From: Tom Errico <thomas.errico@tylin.com>
To: Helen Donaldson <HCD@portlandmaine.gov>
CC: David Margolis-Pineo <DMP@portlandmaine.gov>, Katherine Earley <KAS@portlandmaine.gov>, Jeremiah Bartlett <JBartlett@portlandmaine.gov>, Jeff Tarling <JST@portlandmaine.gov>
Date: 3/24/2015 11:43 AM
Subject: 195 Kennebec Street - Preliminary Transportation Comments

Nell - I have reviewed the application materials and offer the following preliminary comments as it relates to transportation elements.

DRAWN: ADJ DATE: 11.25.14
DESIGNED: ADJ SCALE: 1" = 20'
CHECKED: ADJ JOB NO.: SP-M160
FILE NAME: SP-M160 BASE
SHEET: **C-3.0**

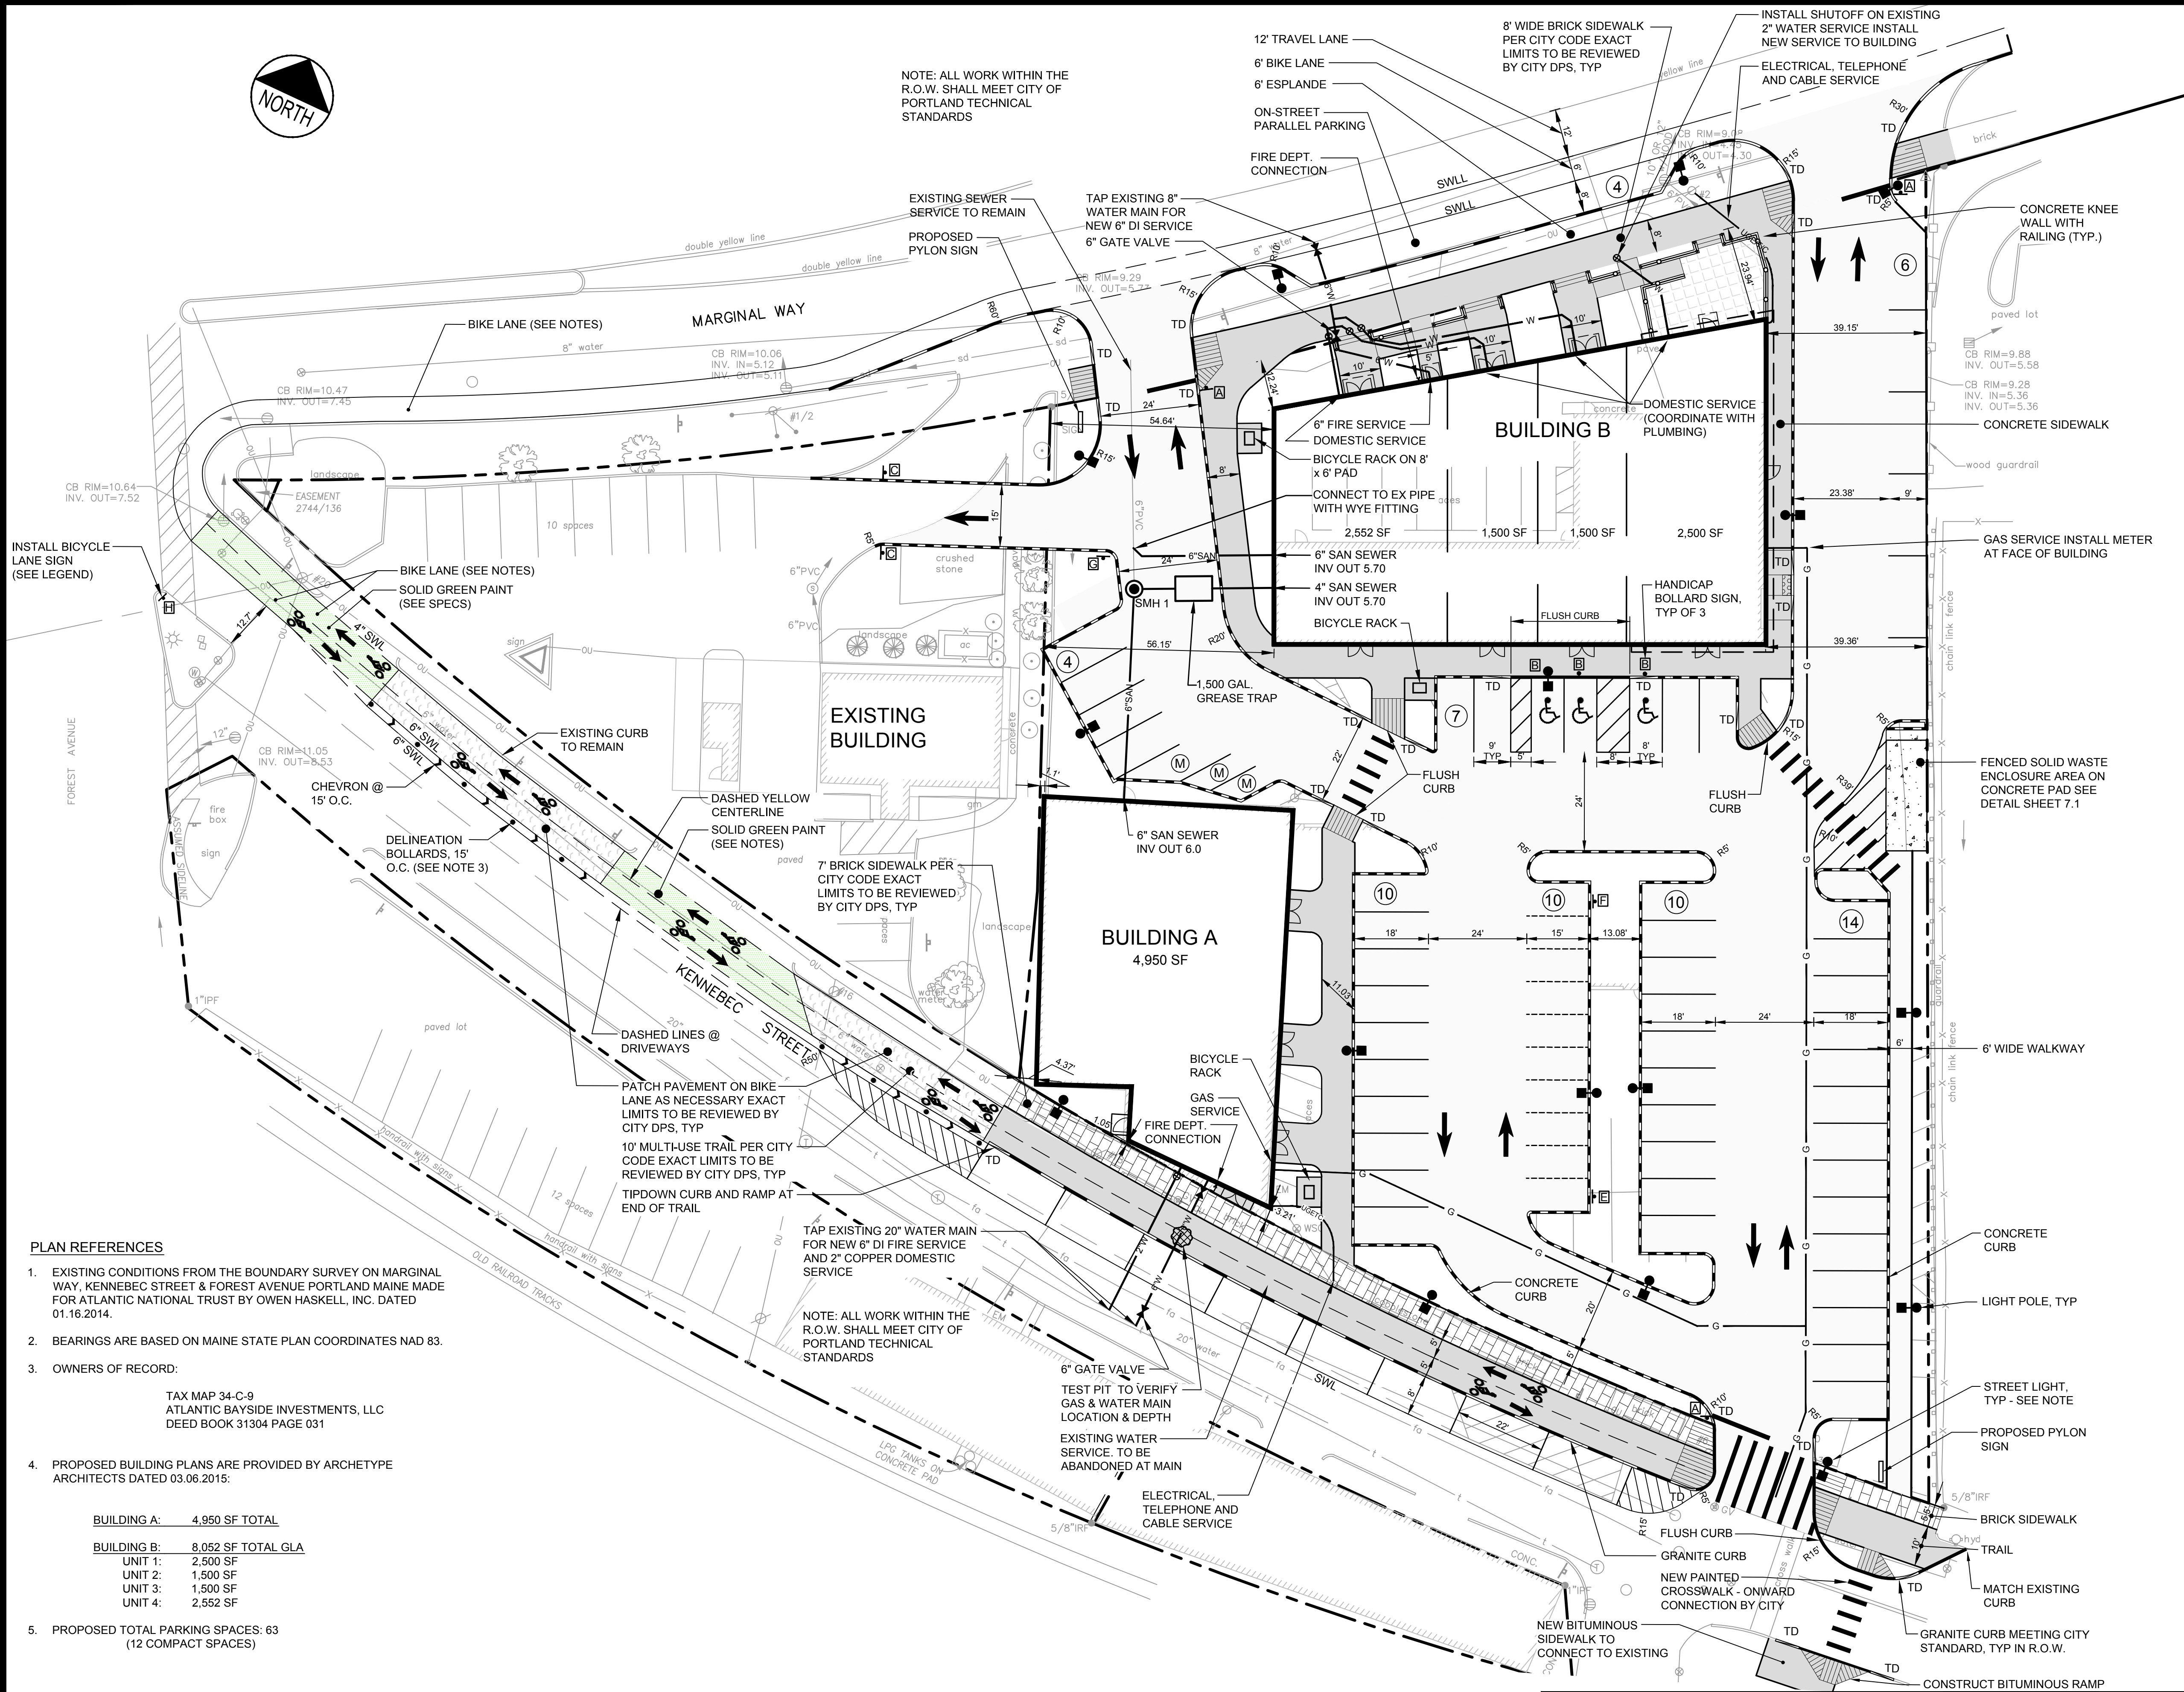
1. The project frontage on Marginal Way shall be adjusted to meet the design principles of the Marginal Way Master Plan (the nearby Gorham Savings Bank Building is a good example). The plans should account for the following:

- * On-street parking
- * The curb line should extend into Marginal Way and generally match the curb line at the Gorham Savings Bank site. The applicant should be cognizant of the transition from Forest Avenue and how vehicles will be aligned.
- * 10-foot brick sidewalk
- * 6-foot bicycle lane

2. The number of driveways provided for the site exceeds those allowed under the City's Technical Standards. From an access management perspective, I'm most concerned about conditions on Marginal Way. Please noted the following:

- * The project incorporates a shared driveway with Enterprise Rental which is a positive access management strategy, particularly when only entry movements into Enterprise will be permitted.
- * Marginal Way traffic conditions, particularly with the influence of Forest Avenue, does concern me as it relates to the westerly driveway. My preference would be to eliminate this driveway, but recognize its importance for Enterprise access needs. A right-turn entry and exit driveway scenario would help to ease my concern regarding traffic impacts, but this configuration would eliminate Enterprise left entry movements, which I suspect would be problematic.
- * The easterly driveway is acceptable to me as the primary driveway although it is suggested that a formal direct pedestrian connection between Marginal Way and Kennebec Street be incorporated.

6. The frontage on Kennebec Street shall be adjusted to meet the design principles of the Somerset Street Extension project. The plans should account for the following:

- * A 10-foot shared use bituminous path to be located next to the granite curb.
- * A 7-foot brick sidewalk along the property boundary.
- * On-street parking will not be permitted.
- * Transition of the shared use path to an on-road cycle track on both ends of the project will be required.

7. The applicant should investigate the possibility of aligning the driveway on Kennebec Street with Brattle Street.

8. Stop bar locations shall be placed prior to sidewalk at the driveways.

10. The plans should incorporate a full ADA compliant crosswalk on Kennebec Street between the site and Brattle Street (this crosswalk currently exists).

11. The configuration of the six parking spaces located along the Enterprise property boundary are non-standardized and dimensional standards

are unclear and I would prefer a more traditional layout.
